OXFORDSHIRE COUNTY COUNCIL'S RESPONSE TO CONSULTATION ON THE FOLLOWING DEVELOPMENT PROPOSAL

Application no: 22/03883/F

Proposal: Development of 96 Dwellings (50% affordable housing), extension to Bicester Road Cemetery with associated access (from Bicester Road), open space, landscaping and infrastructure

Location: Land North Of 66 And Adjacent, Water Eaton Lane, Gosford

Drawing:  
Bike Store 01

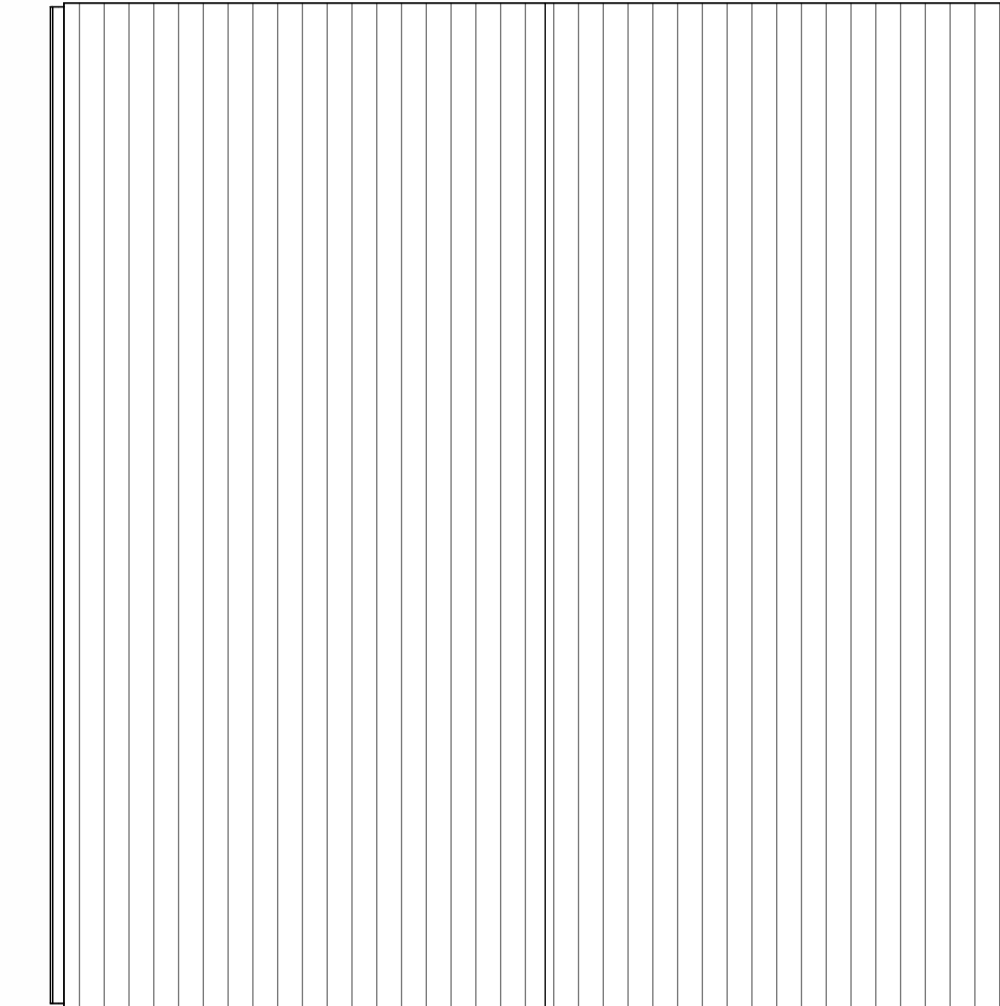
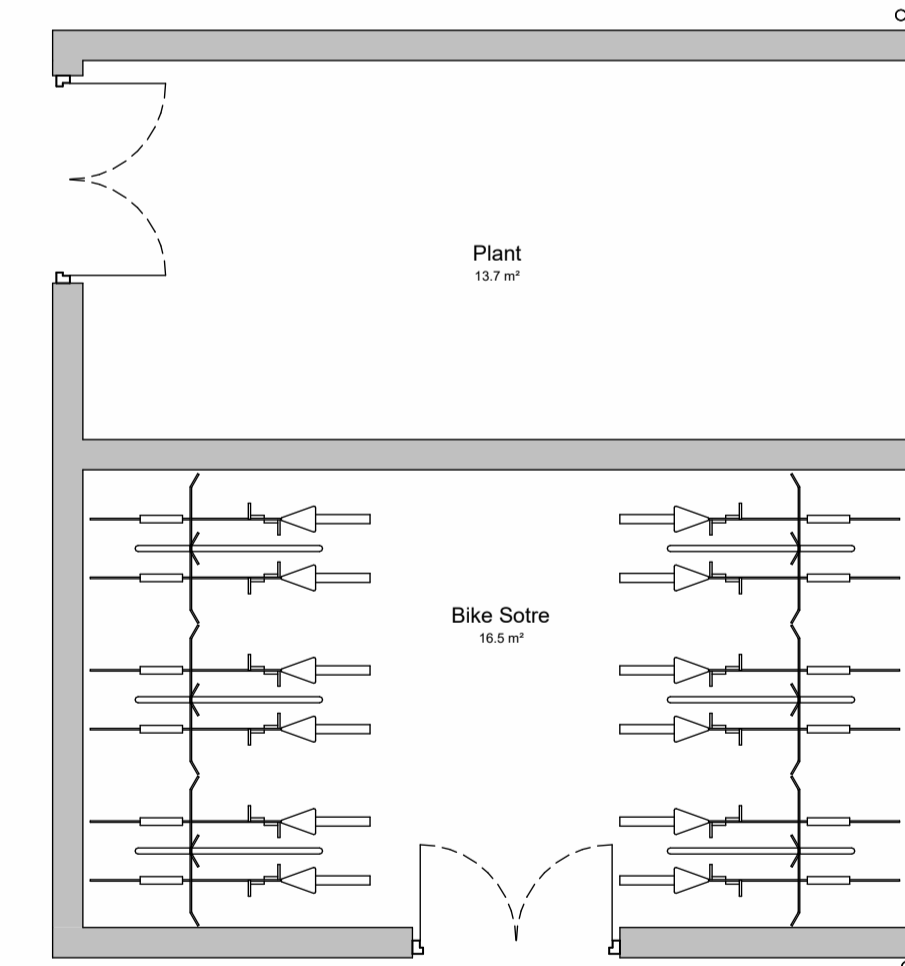
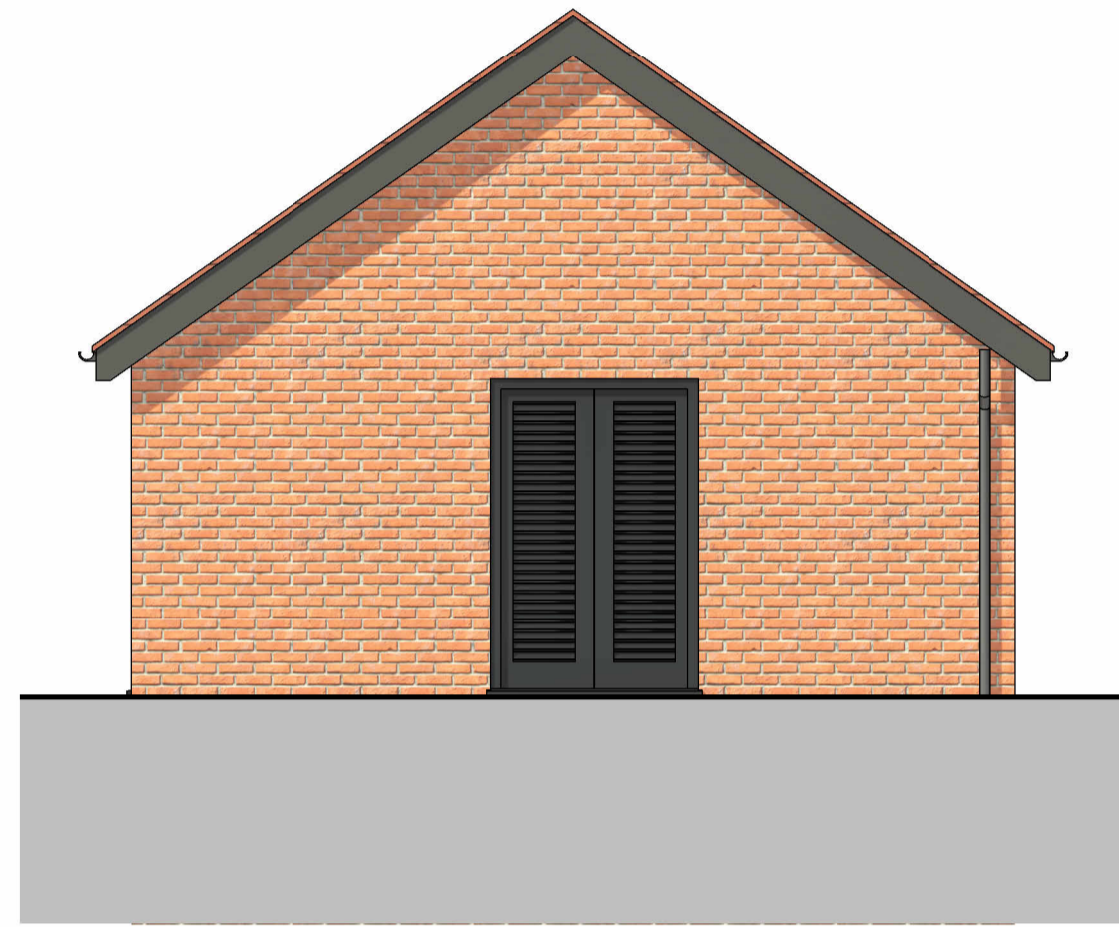
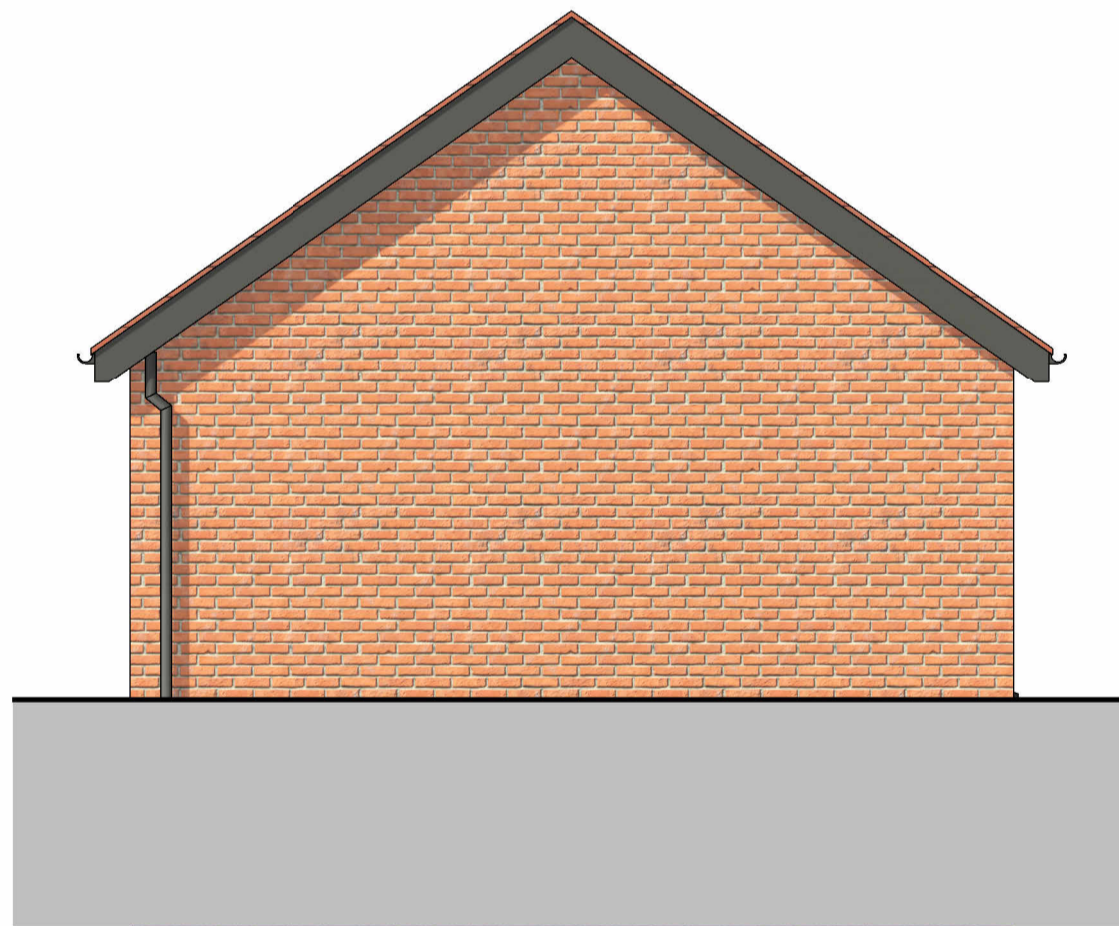
Para 2.28 asserts that cycle parking has now been amended in accordance with the HA's comments. While the willingness has been expressed that *'the increase in cycle parking has been achieved by increasing the available cycle parking stands in the bike storage area'*, this provision must be shown on plans. For this, I expect to see revised plans (including apartment block plans) supporting this claim that bike storage facilities have now been increased. **(Reason for objection)**
